CITY OF ALBUQUERQUE

February 7, 2022

Re: Blue Cross Veterinary Clinic
1650 University NE
Traffic Circulation Layout
Architect's Stamp 11-19-2021 (H15-D015B)

A6 SCALE: 1"=5'

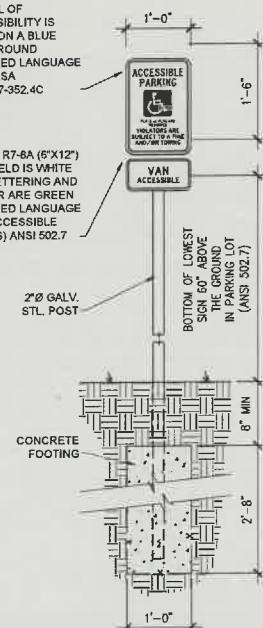
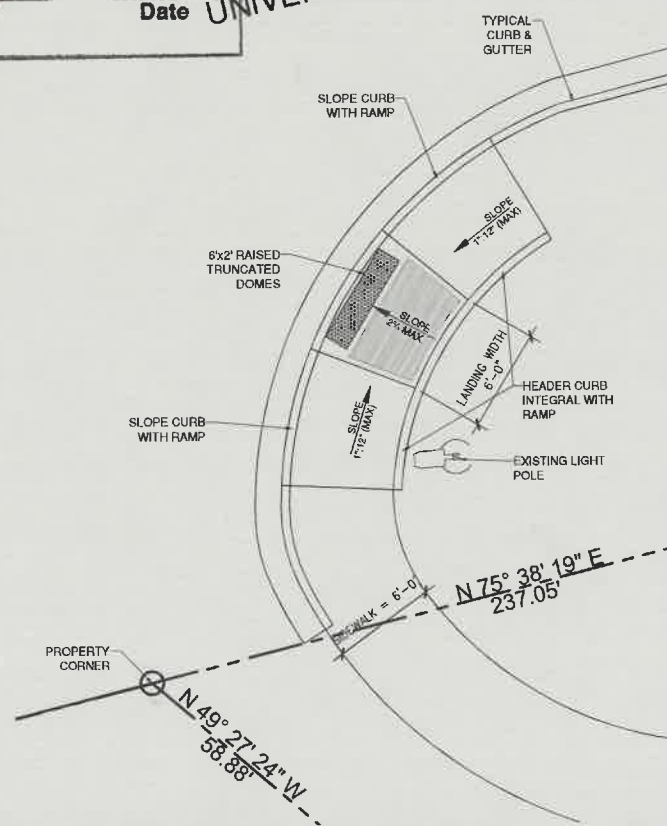
1. Detail A6/TCL2: The slopes need to read 12:1 max (8.33 %Max).
2. Motorcycle parking spaces: Provide pavement markings MC on each stall and details of text size and color.
3. Provide a copy of receipt for \$75 re submittal fee paid.
